**RE: The Lofts at Winrock  
7500 Indian School NE  
Grading & Drainage Plan  
Engineer's Stamp Date: 3/6/25  
Hydrology File: J19D089  
Case # HYDR-2025-00112**

Based upon the information provided in your submittal received 4/2/2025, the Grading & Drainage Plan **is not** approved for Building Permit and Grading Permit. The following comments need to be addressed for approval of the above referenced project:

C101

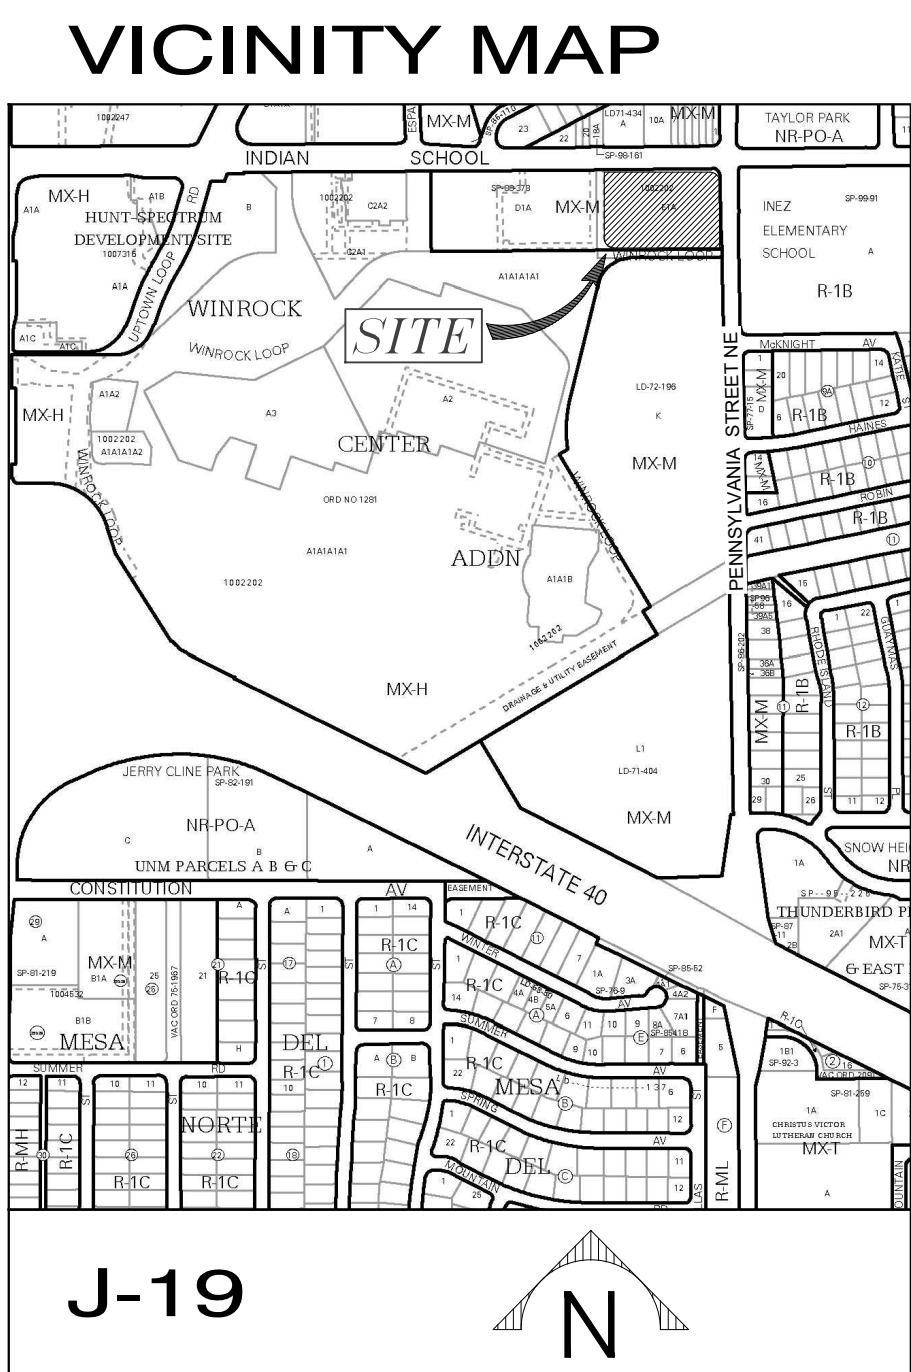
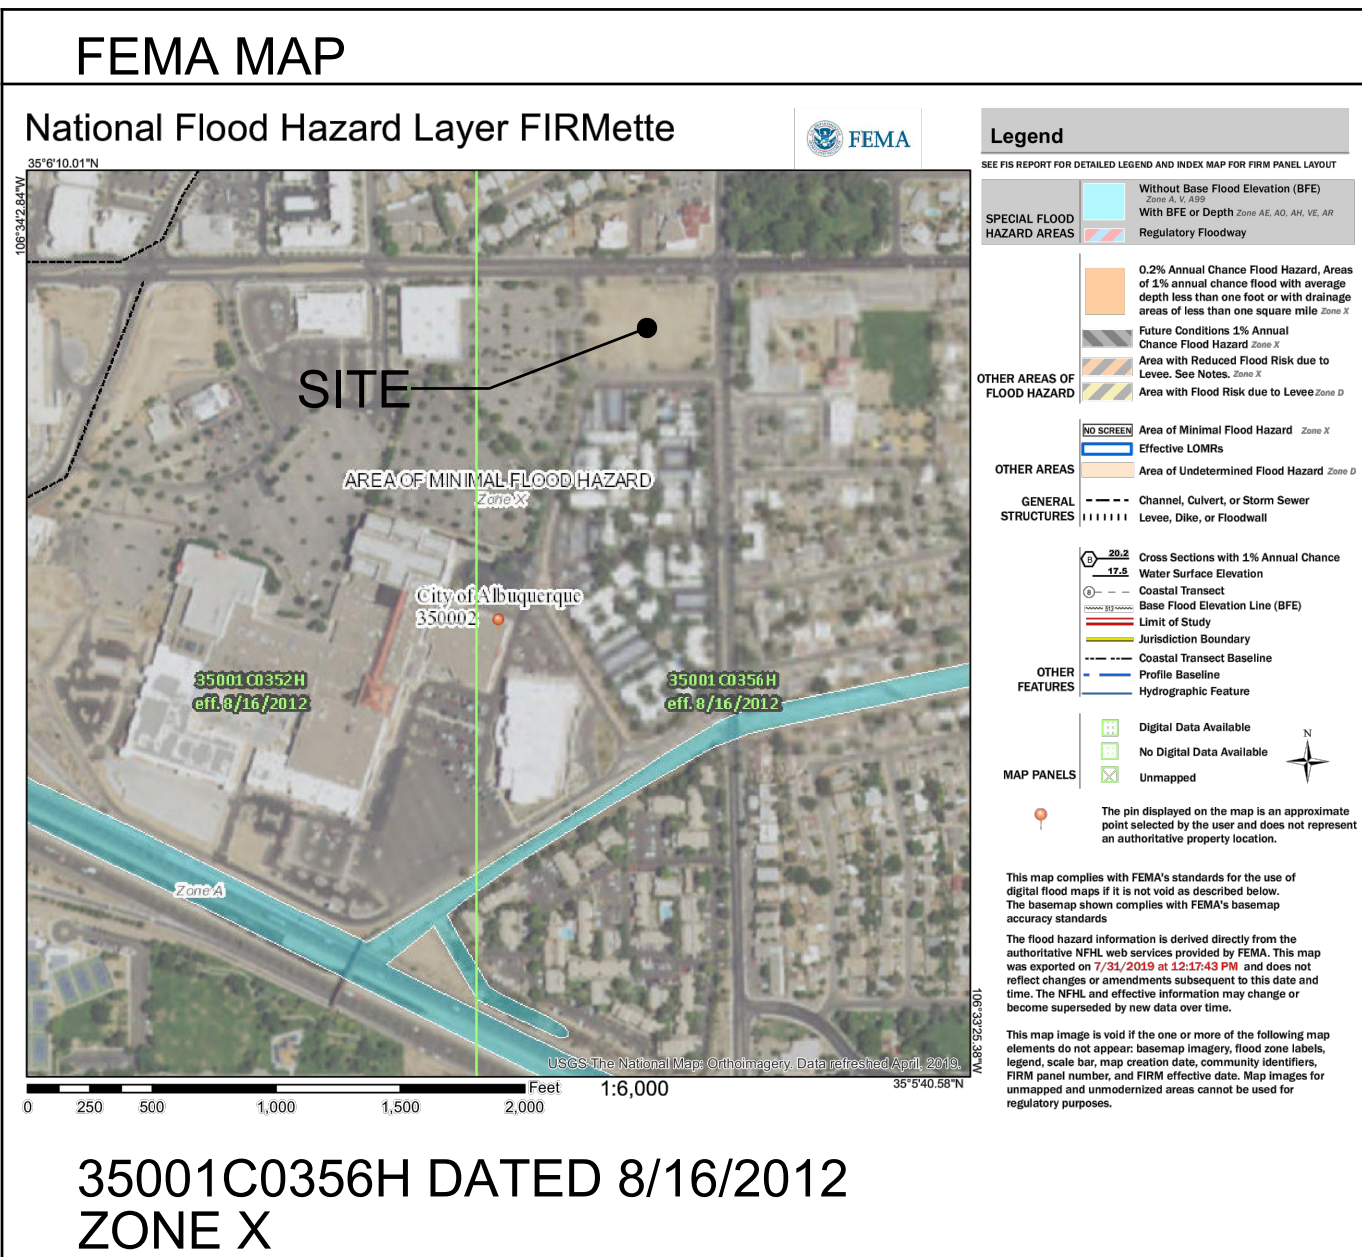
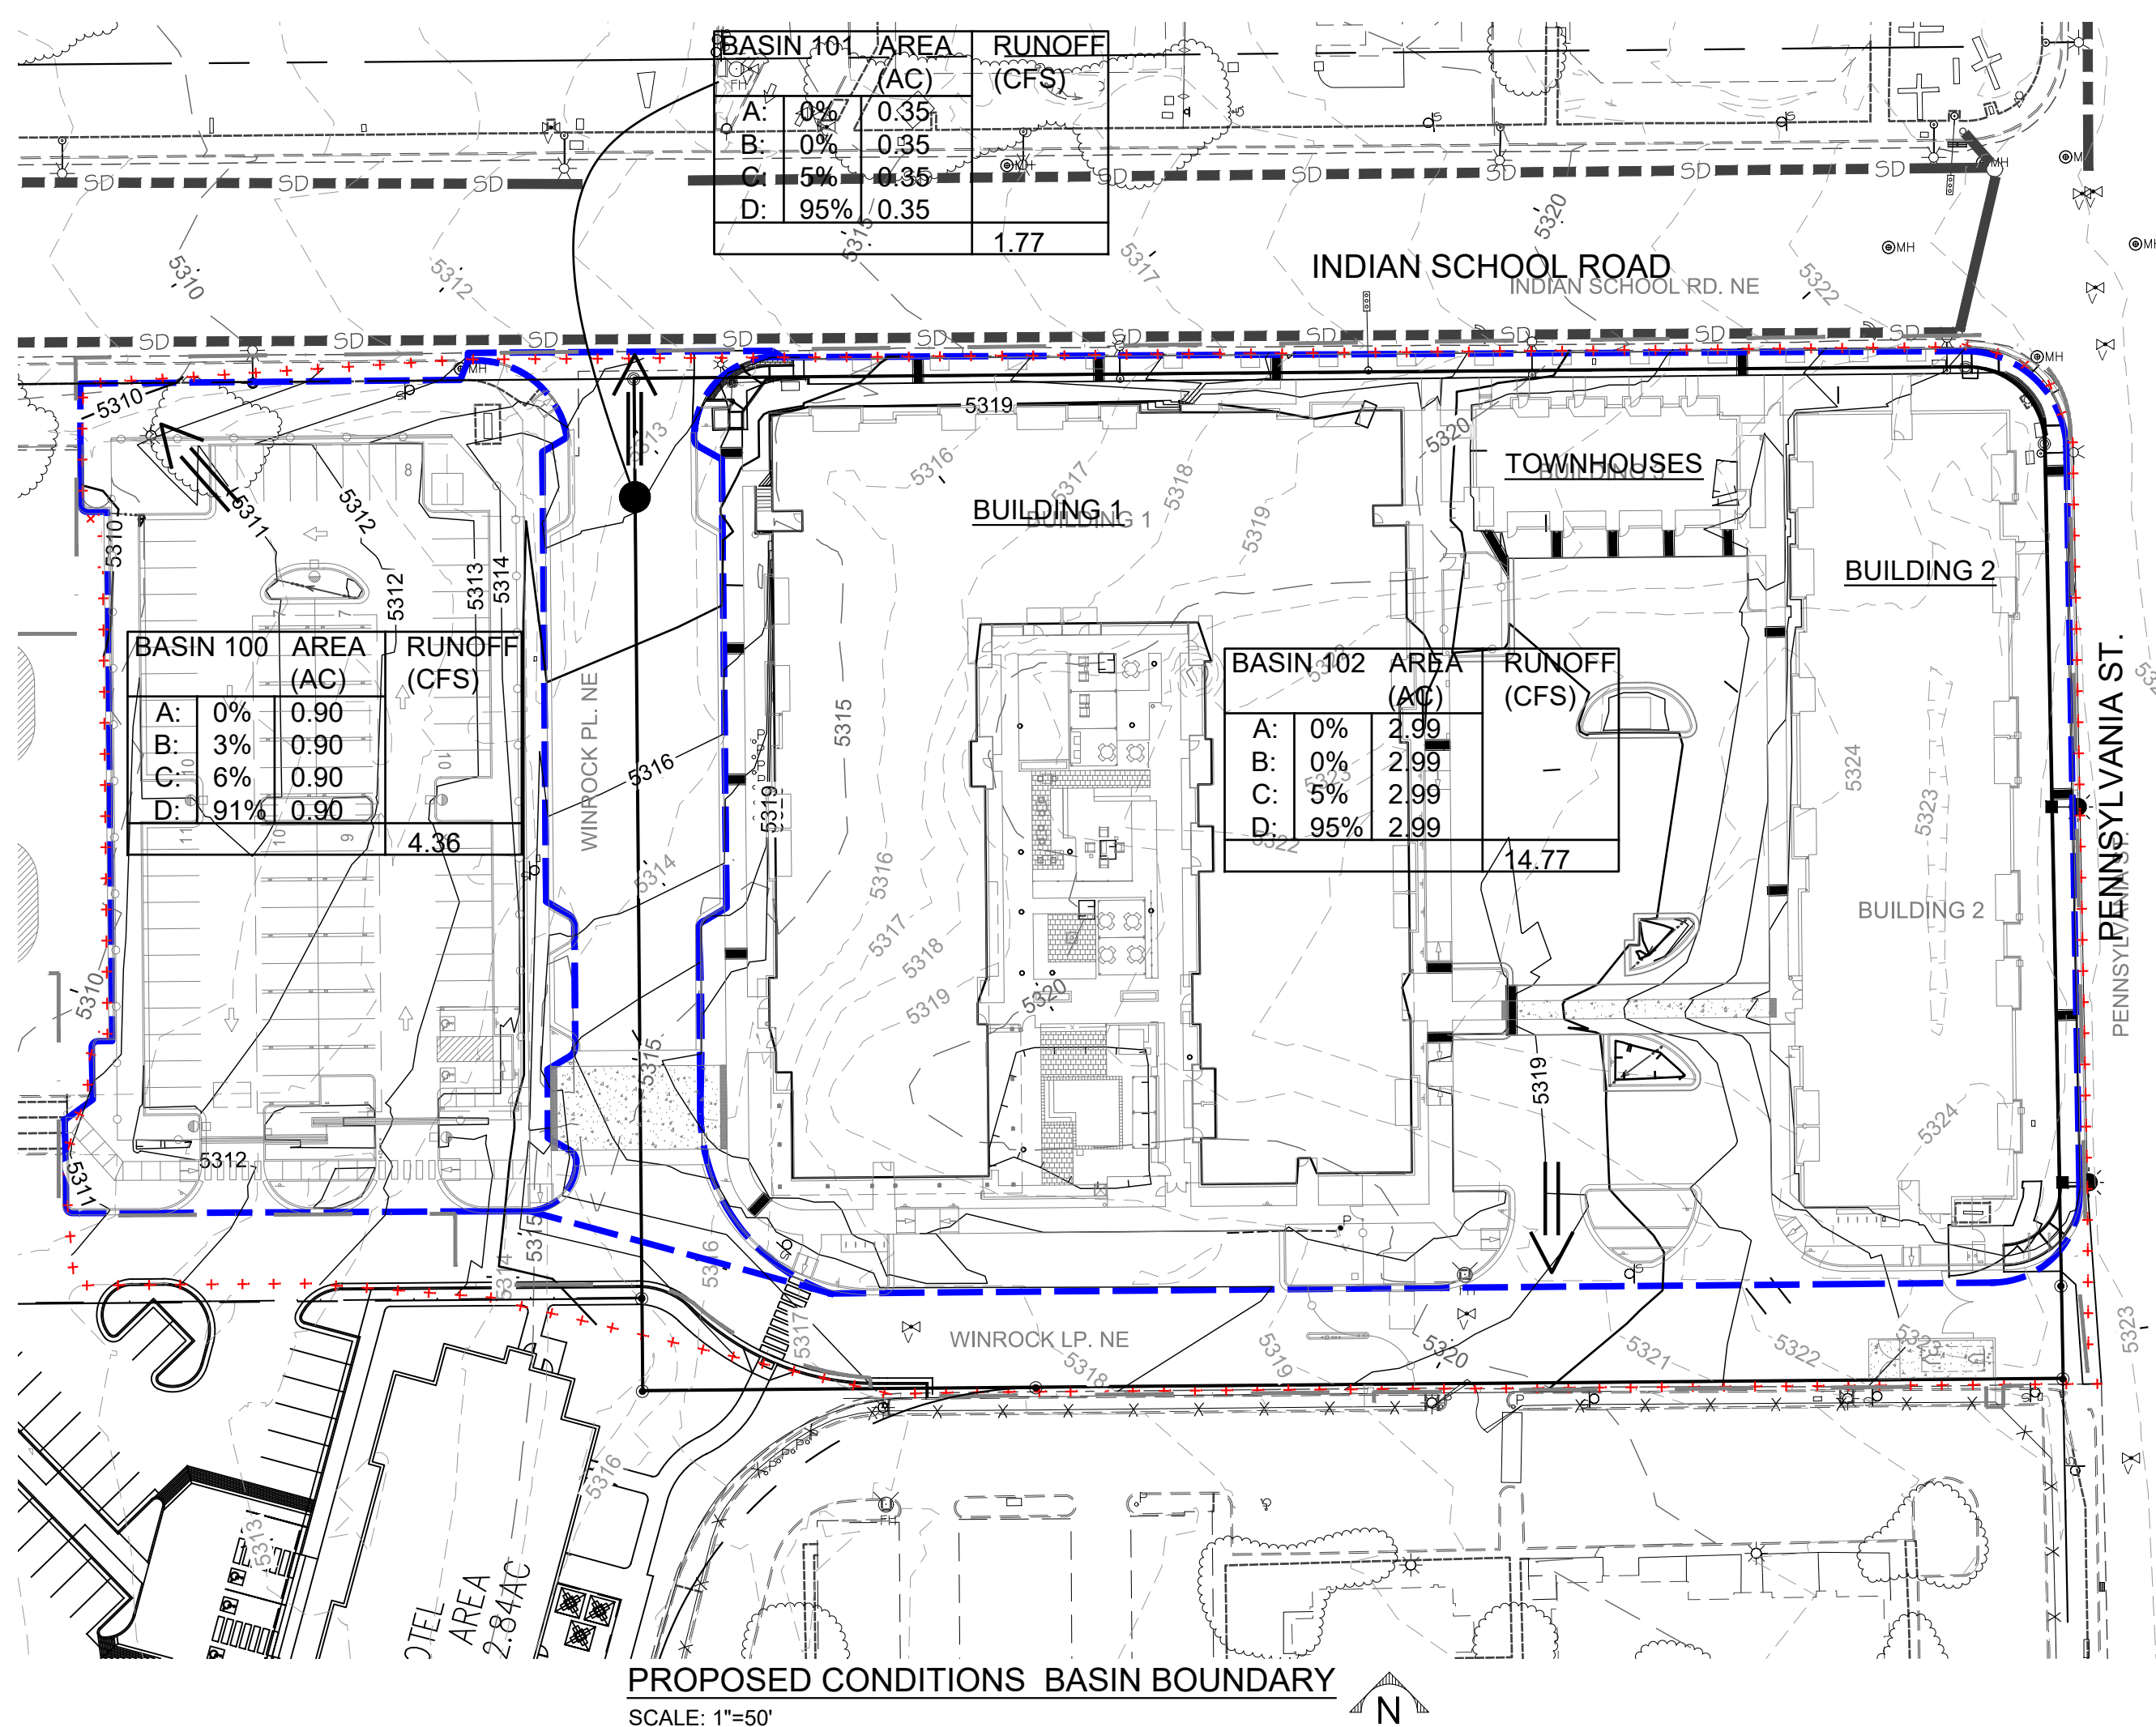
1. Payment in Lieu (Amount =  $1,243\text{CF} \times \$8/\text{CF} = \$9,944$ , per Drainage Plan sheet 1 of 17) of onsite management of the SWQV must be made. Please submit a Waiver Request form to Hydrology for approval.
